Lead Local Flood Authority

Date 11 November 2025

RE: BE/29/25/DOC - Land at Oldlands Farm, Newlands Road , Bognor Regis, PO22 9NN

This application is for the discharge of conditions Approval of details reserved by condition imposed under reference BE/150/22/OUT relating to condition number 23 - maintenance and management of the surface water drainage system. Substitute Drainage Specification.

Drawing Title
Drainage Layout

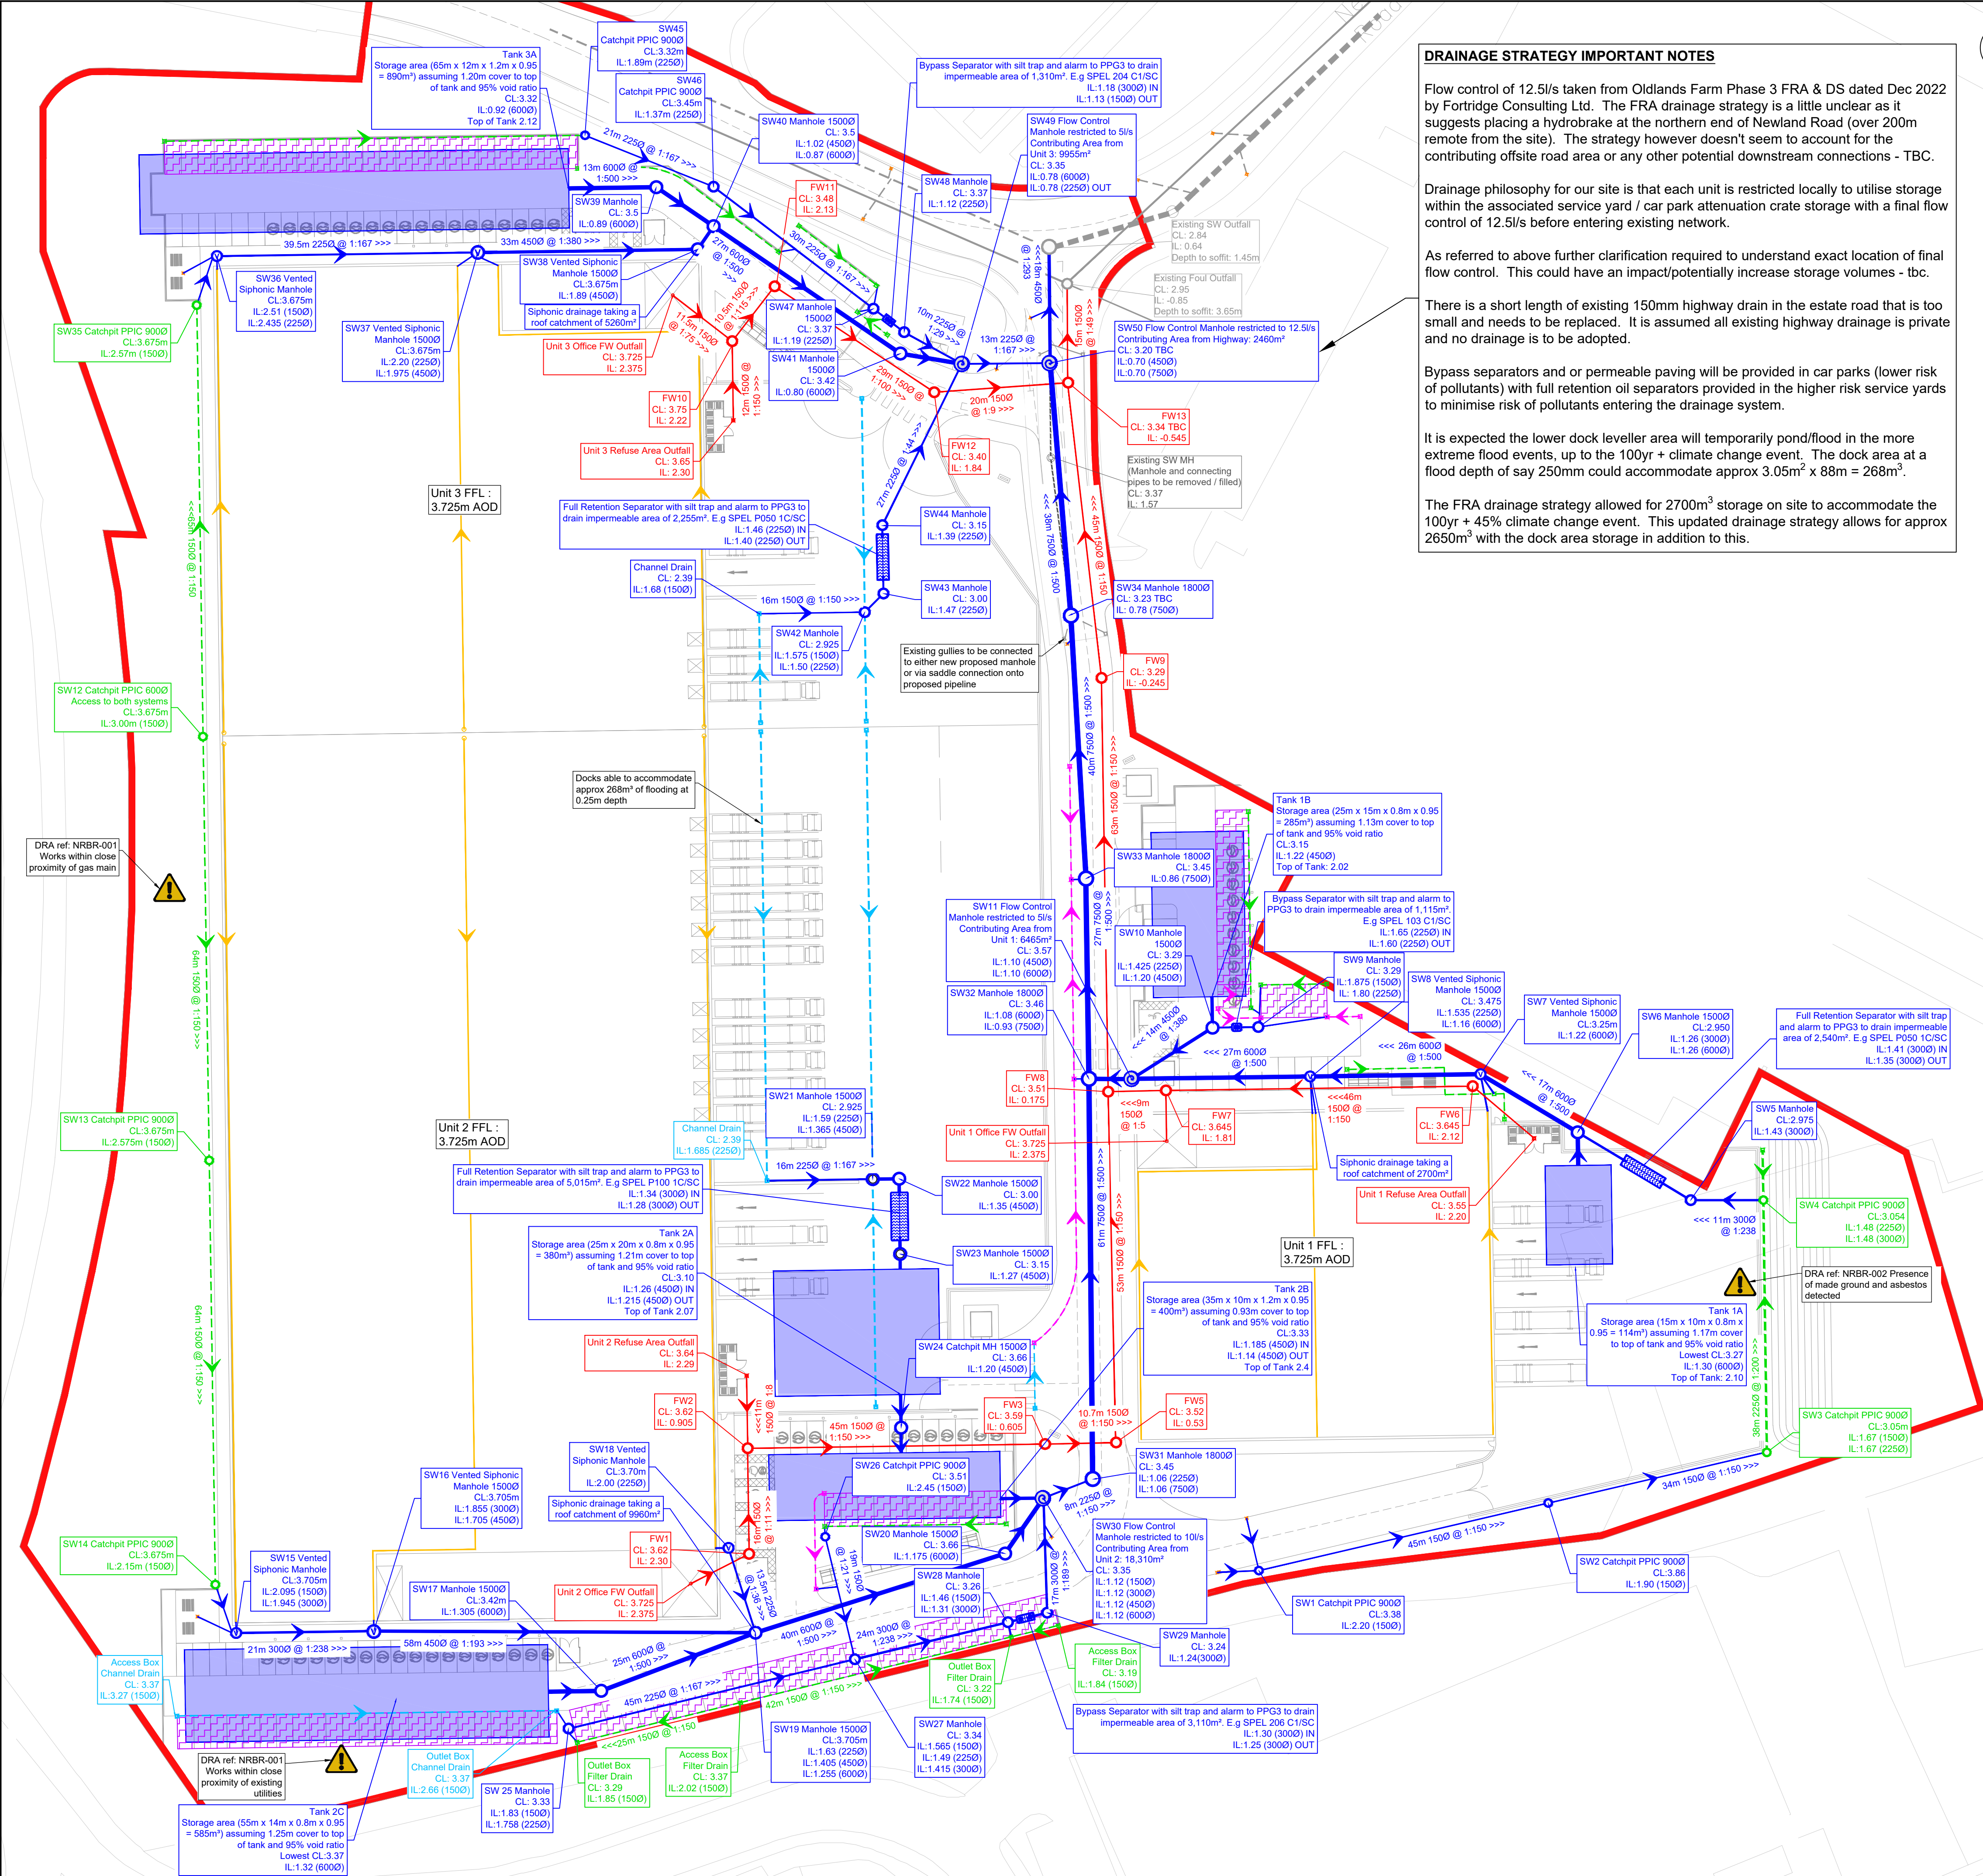
Until the drainage strategy is formally approved, which is currently under consideration as part of a live application, this condition cannot be discharged. It is also noted that for the level of application any plans must be at the appropriate 'For Construction Status' with no reference to 'Subject to change/approval' annotations.
